CITY OF ALBUQUERQUE

Re: 915 Silver SE
Lot 20, 915 Silver Ave SW Albuquerque NM 87102
Traffic Circulation Layout
Engineer's/Architect's Stamp 07-11-2019 (K14D118)

Based upon the information provided in your submittal received 07-15-19, the above referenced plan cannot be approved for Building Permit until the following comments are addressed:

C-201

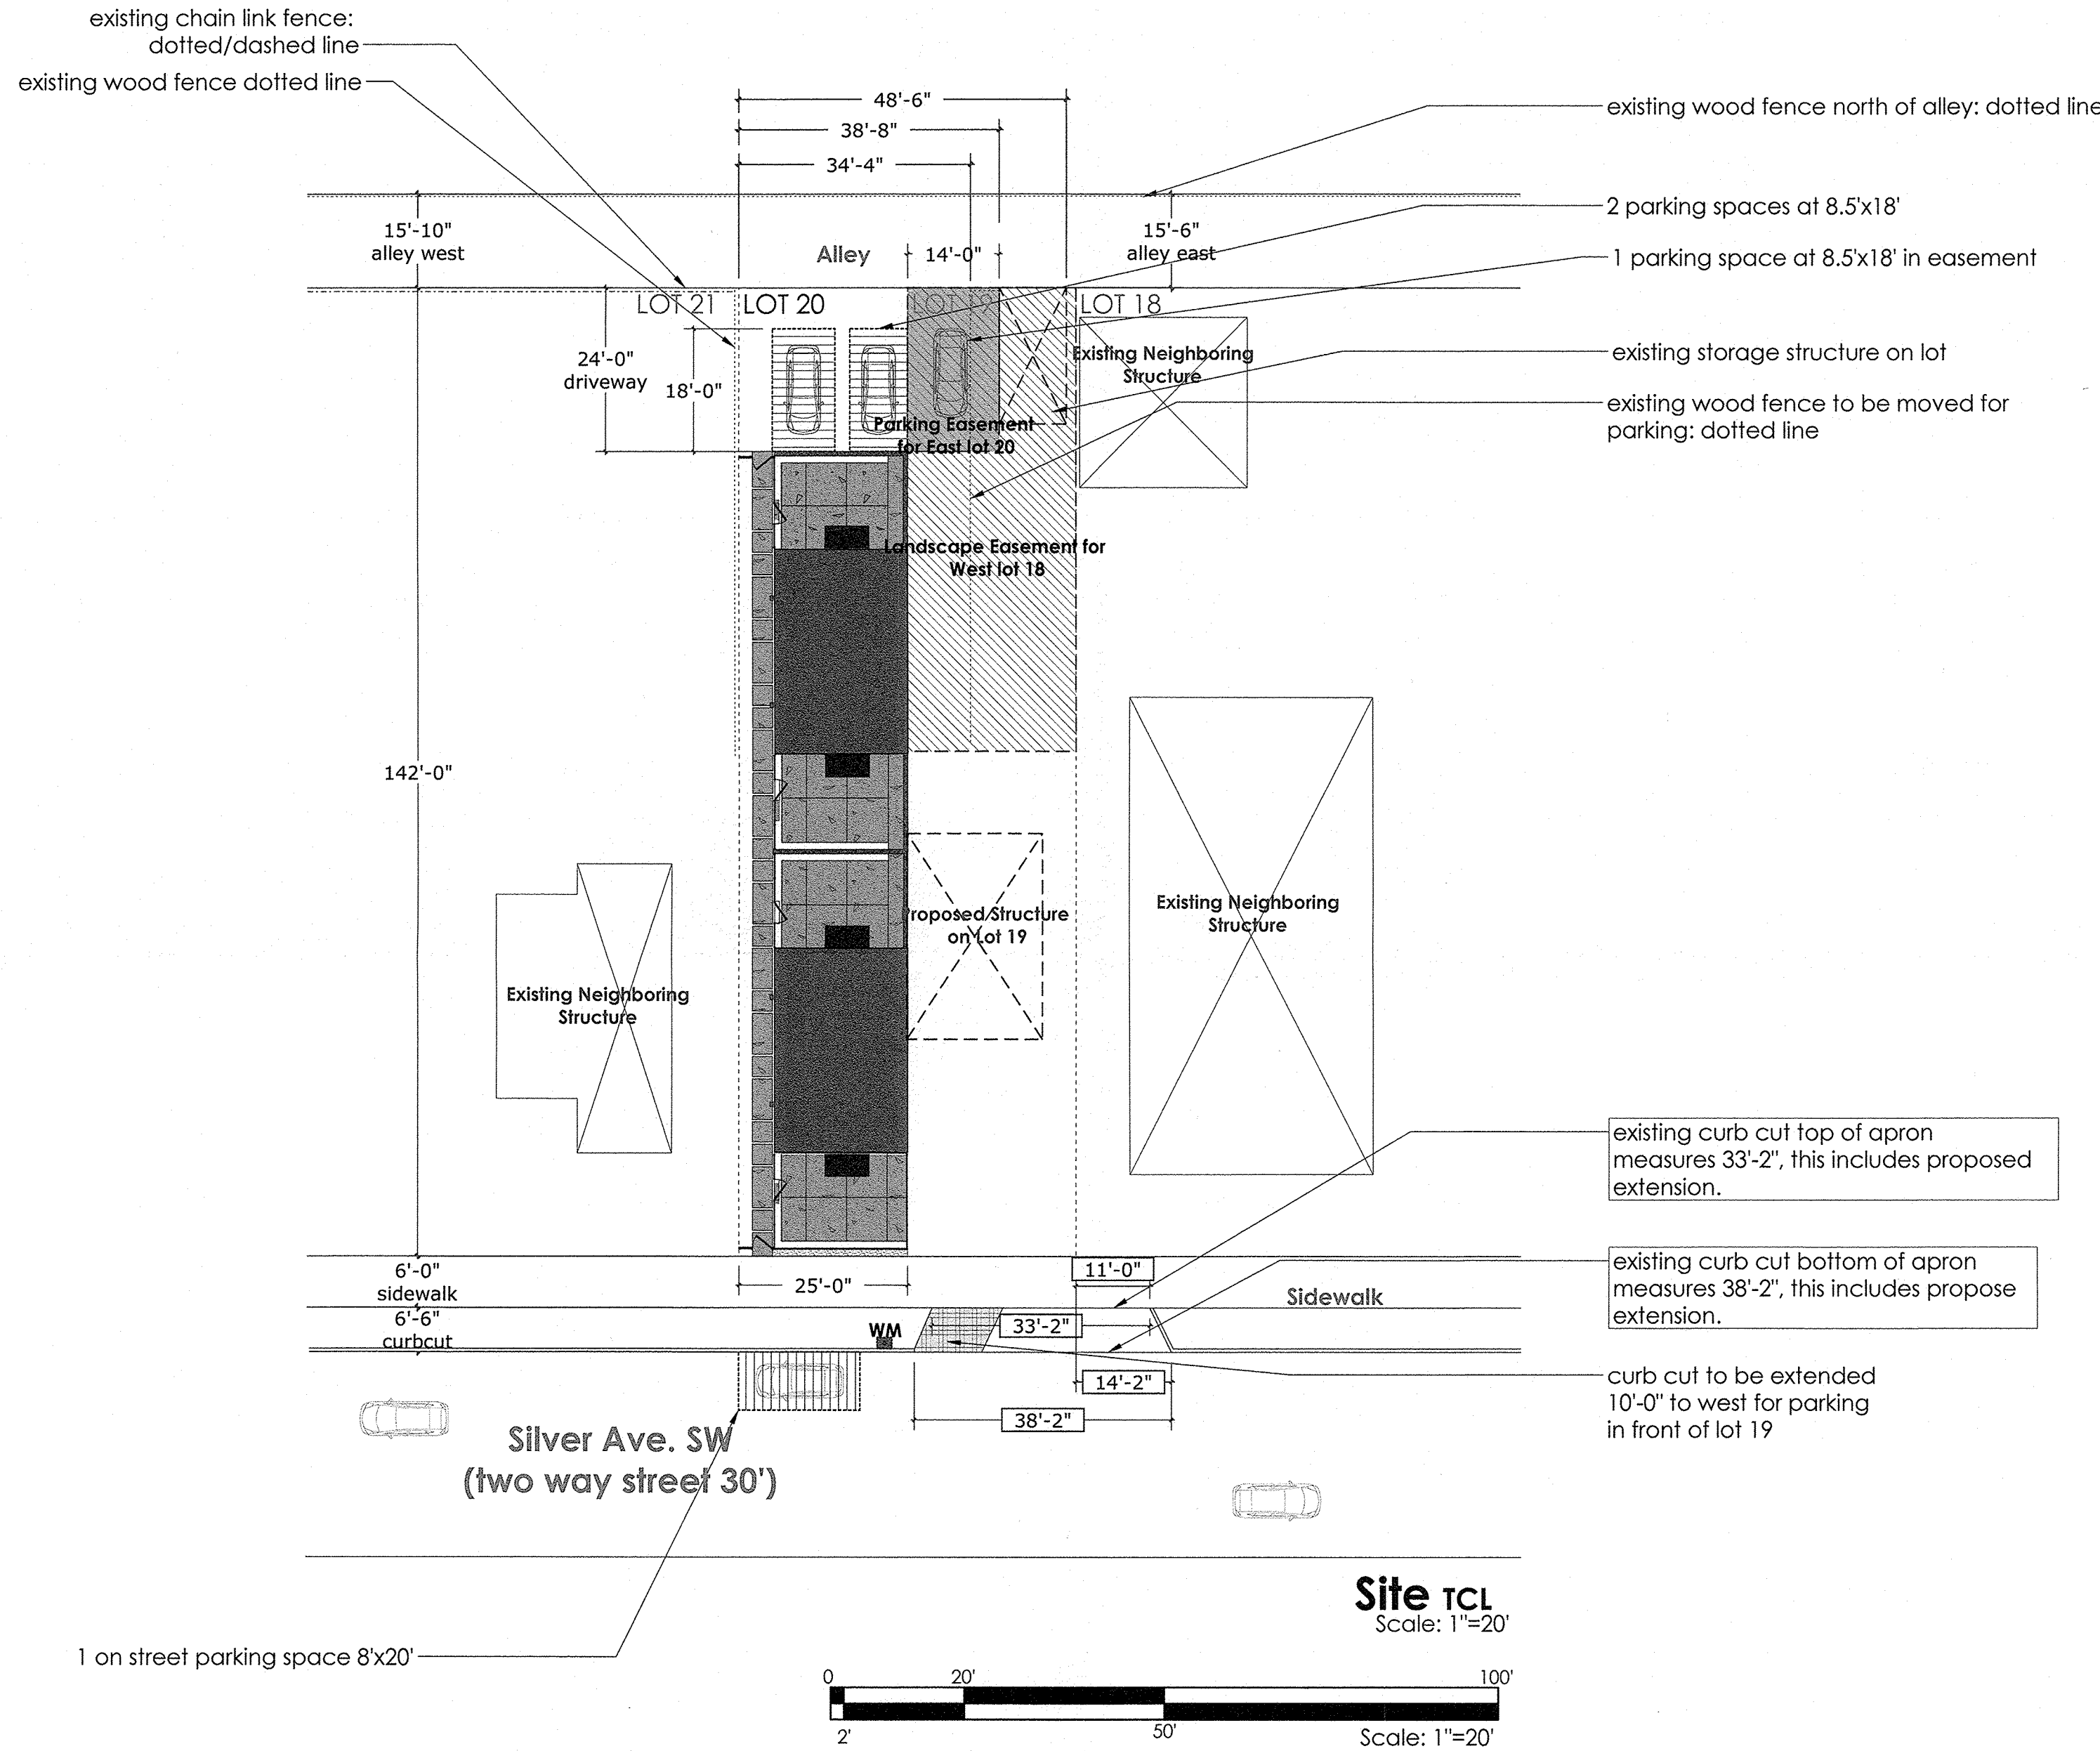
1. Please show a vicinity map showing the location of the development in relation to streets and well known landmarks.
2. List the number of parking spaces required by the zoning code as well as the proposed number of parking spaces including bicycle and motorcycle parking.
3. Provide parking easement document.
4. Show the dimension of the on street parking.
5. Per the Development Process Manual, Chapter 27 Drafting Standards, "Standard sheets must be 24" by 36" having a margin of 2' along the left and 1" on the top and bottom".
6. A scale of 1"=20' is recommended for sites less than 5 acres.
